Attachment A: Advice on the Gateway Certificate application: Caroona Coal Project

Technical assessment by the NSW Office of Water for the Minister for Natural Resources, Lands and Water

Caroona Coal Project – Application for Gateway Certificate

Figure 33 Calibrated Model Parameter Sensitivities

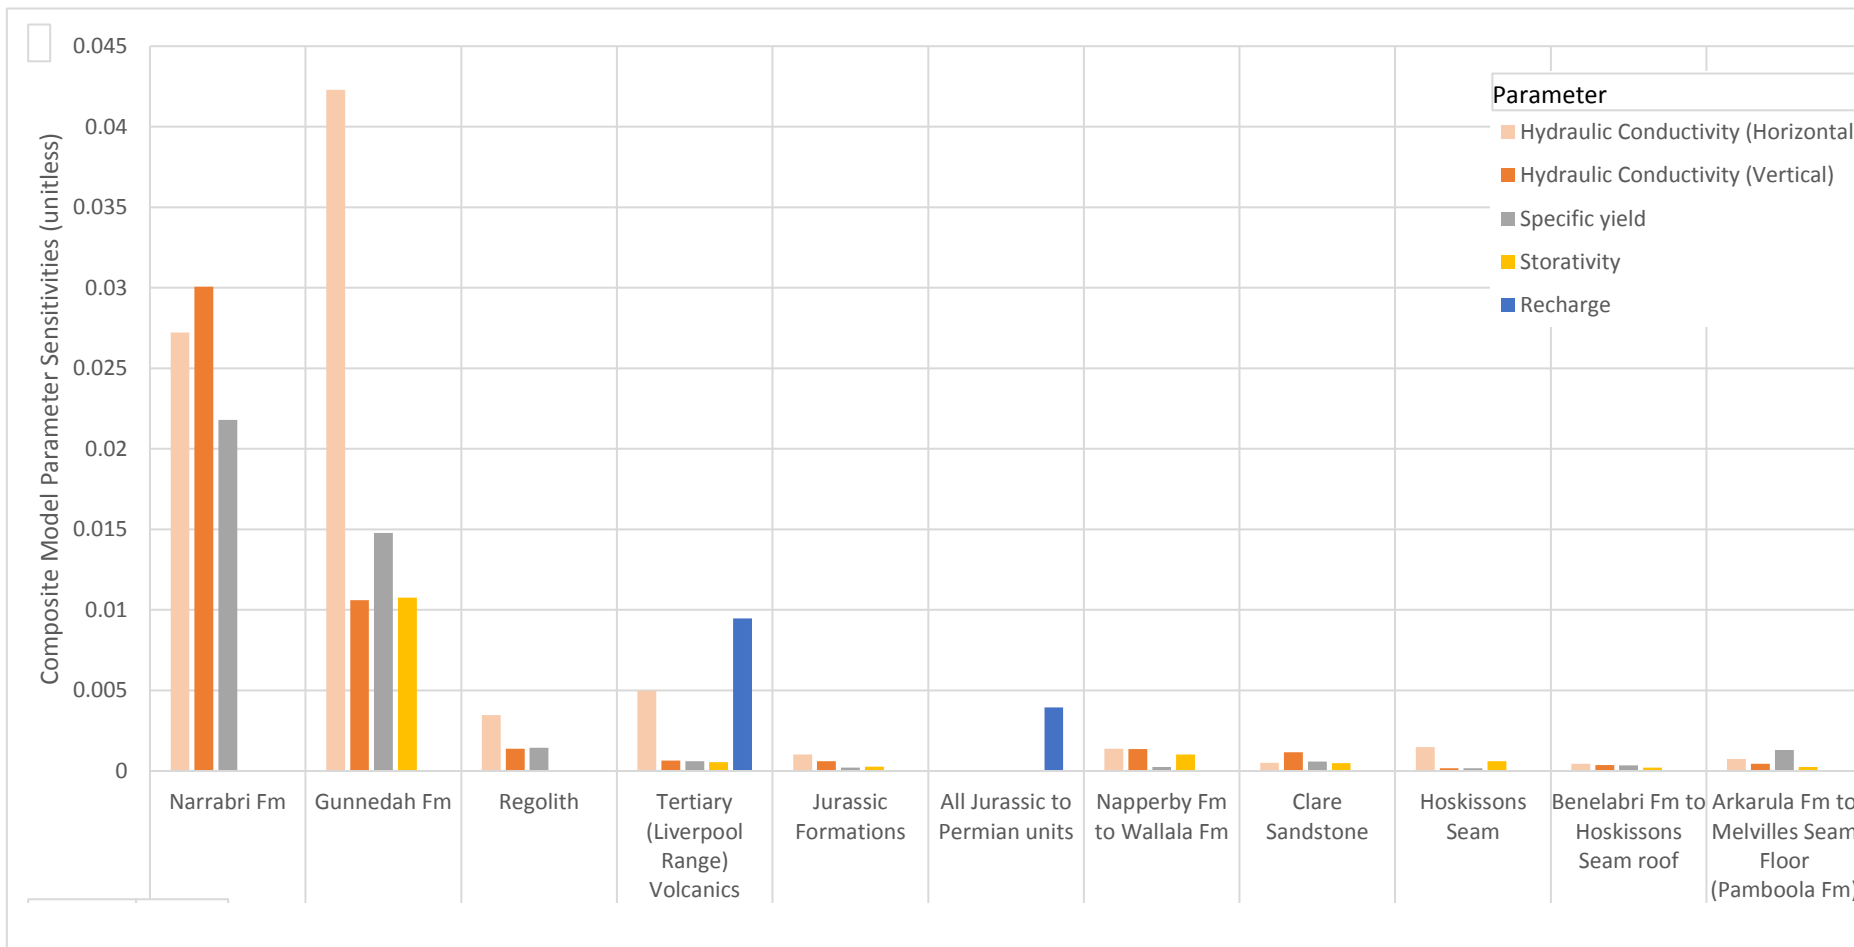
- 20. The potential impacts of the Watermark Coal Project located immediately to the north are applied cumulatively to the Caroona impacts.
- 21. The sensitivity of model predictions to model parameters is assessed in a limited way. Vertical hydraulic conductivity of the layers above the coal seam, assumed to be the dominant parameter affecting mine inflows, is tested to one magnitude higher. The dominance of this parameter compared to others is not proven and must be evaluated to a higher degree in the EIS model. The impact of variability of other model parameters should also be assessed in the EIS model.

- 11. The EIS model should contain a higher level analysis of model parameter sensitivities and a more reliable (or better documented) identification of parameters with greatest potential to affect model outcomes. Such analysis should guide the construction of scenarios used for predictive modelling.

- 14. The need for more rigorous assessment of model parameters is required. The EIS model report should justify the focus on identified sensitive parameters used for predictive scenarios.

Figure 36 Modelled Mooki River Baseflow Impacts

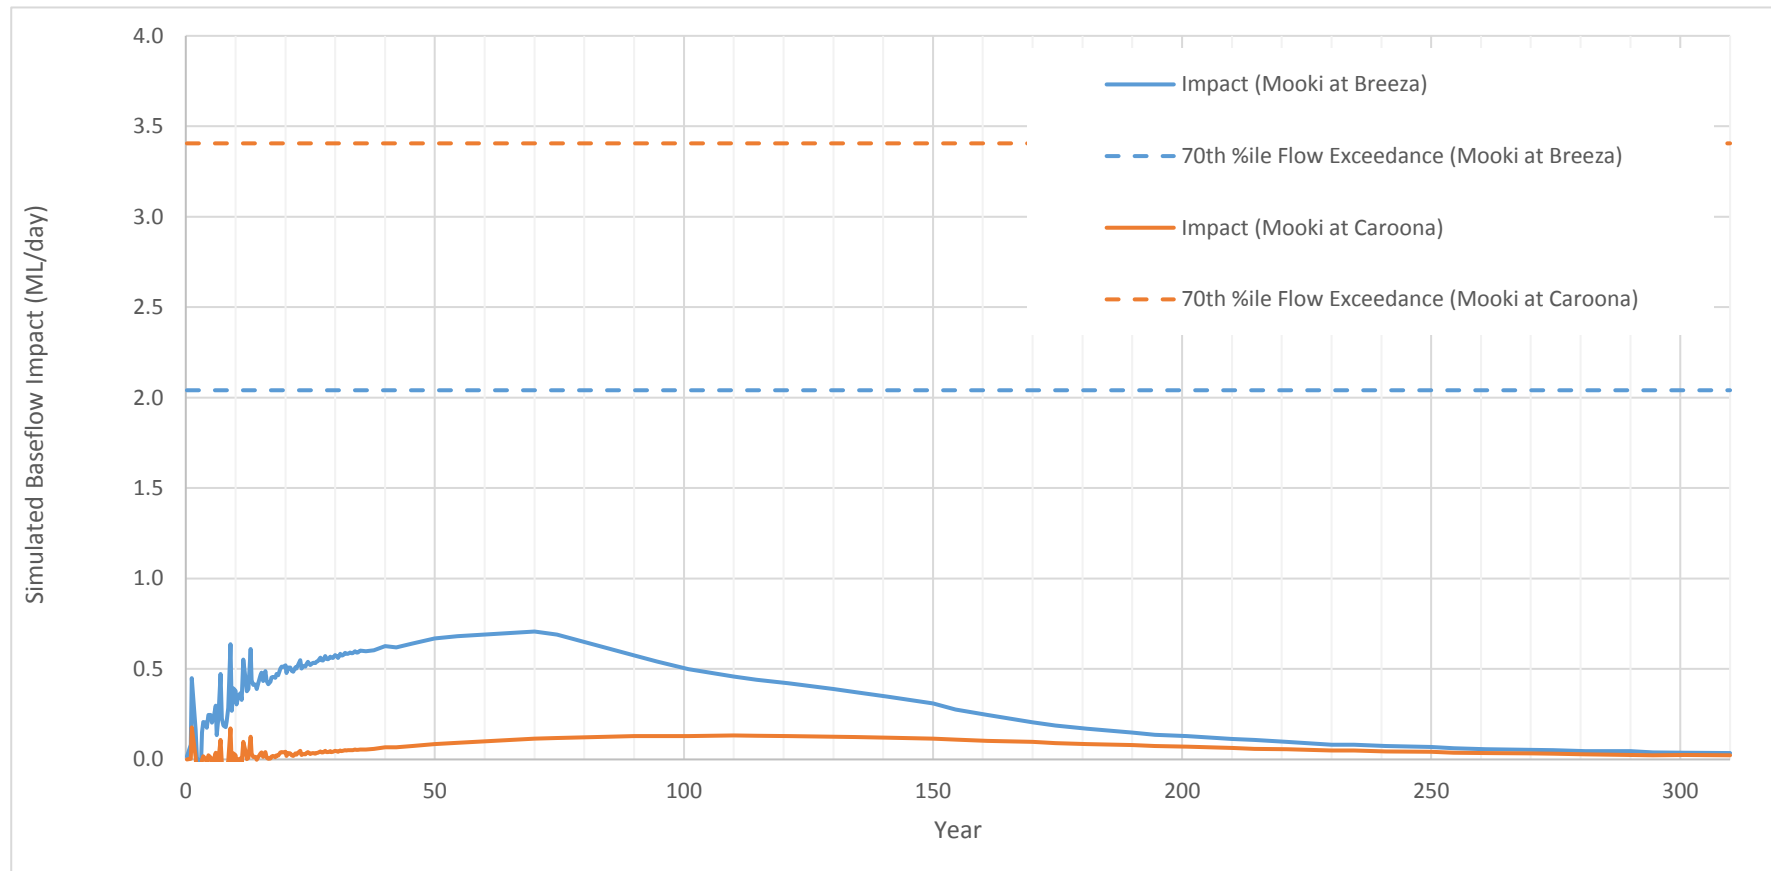
- 6. The closest long wall panel is within 250 m of the Mooki River. The Subsidence Assessment report identifies that there will be no impact on the Mooki River, however the groundwater modelling report estimates that water will be taken from the river. There is a potential connection between the mine and the Mooki River which requires further assessment.

- 3. Impacts upon all potentially affected surface water sources (including the impact of surface cracking due to land subsidence) should be assessed, the volume of estimated take quantified, and the licensing requirements for that take be considered.
